**Wooten Engineering**

February 27, 2018

RE: Project Number 1004167 (17EPC-40043); Site Development Plan for Building Permit  
DRB Application addressing the Conditions of Approval

**1 WEST EXTERIOR ELEVATION**  
A5.1 SCALE: 1/8" = 1'-0"

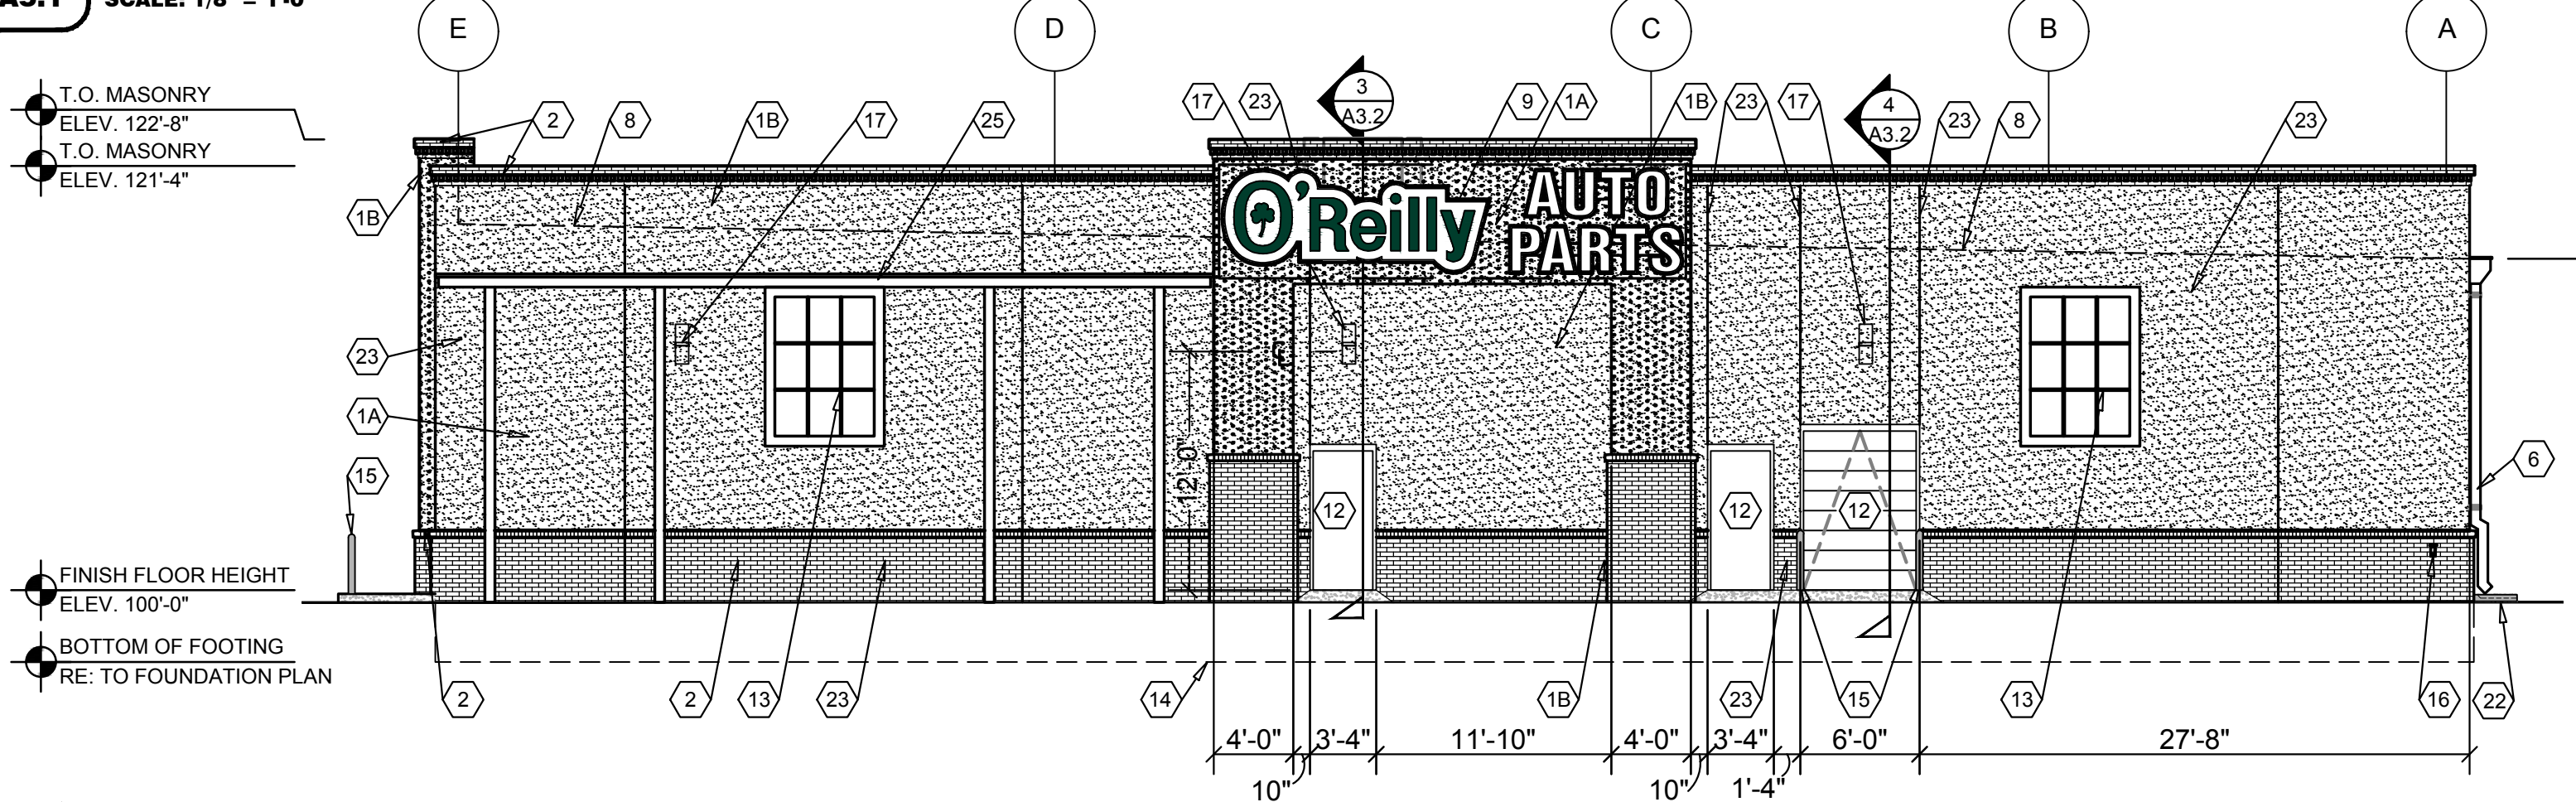
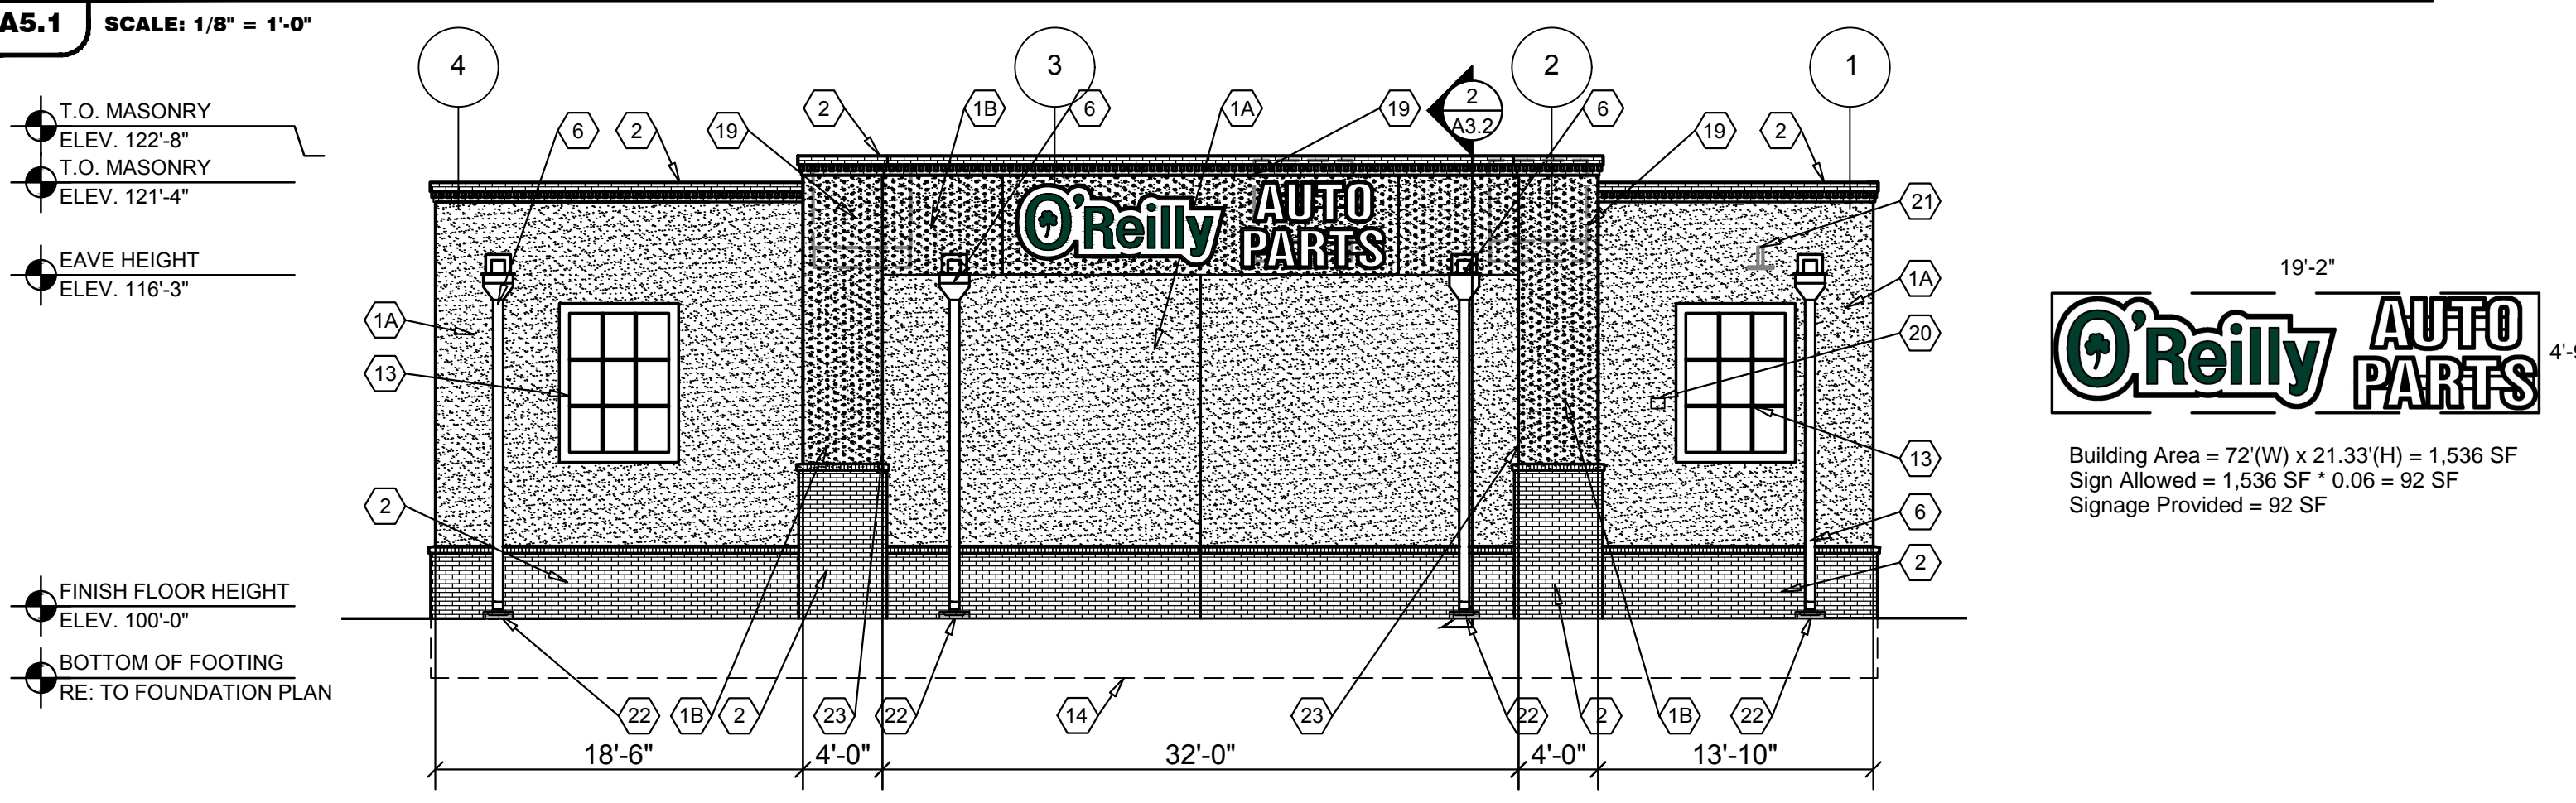
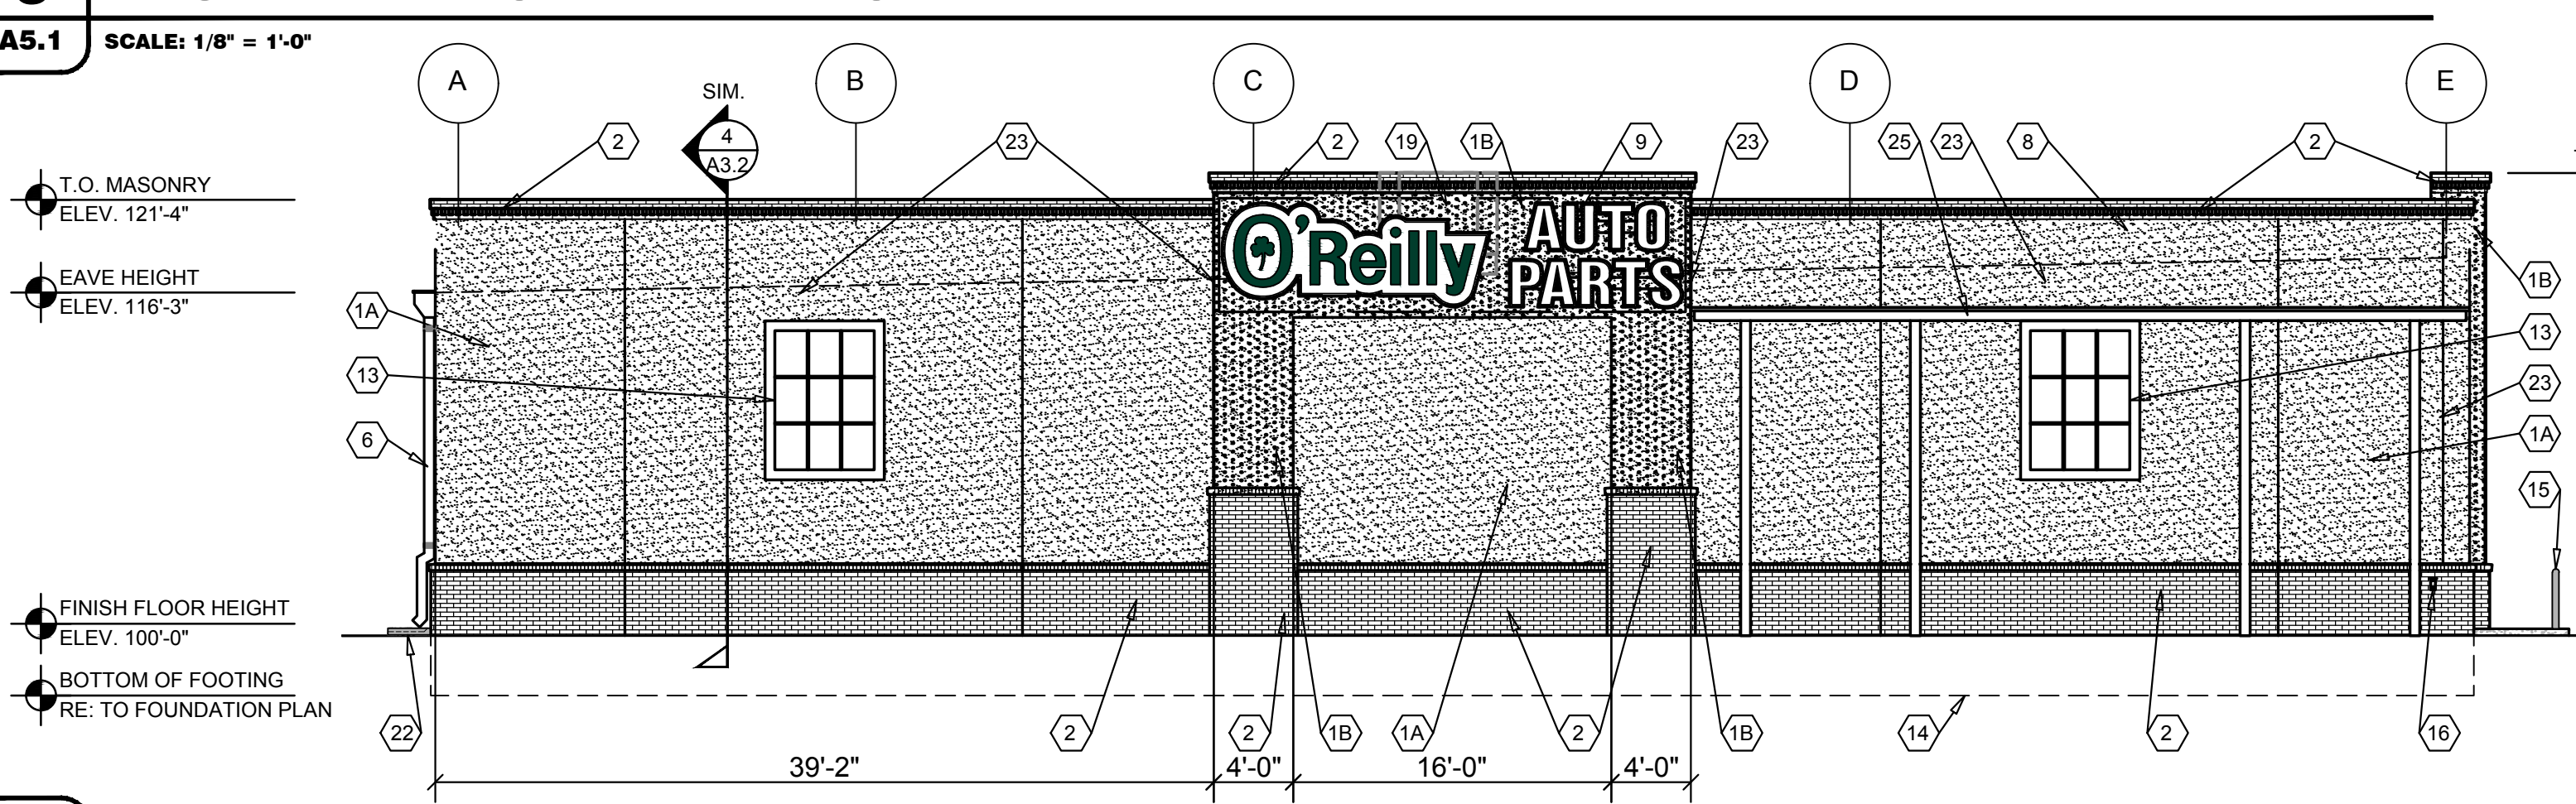
- A. The windows shall be multi-paned and trimmed in white. (Standard G30b2).  
**RESPONSE:** *The windows have been updated and Catalina Lehner has agreed that the windows are now in compliance.*

- B. The coping and wainscoting shall be real red brick (Standard G3-b2).  
**RESPONSE:** *The color has been modified to real red brick and Catalina Lehner has reviewed and concurred with the revised elevations.*

- C. Two decorative windows (see A, above) shall be added to each of the south, east, and north elevations.  
**RESPONSE:** *The decorative white, multi-paned windows have been added.*
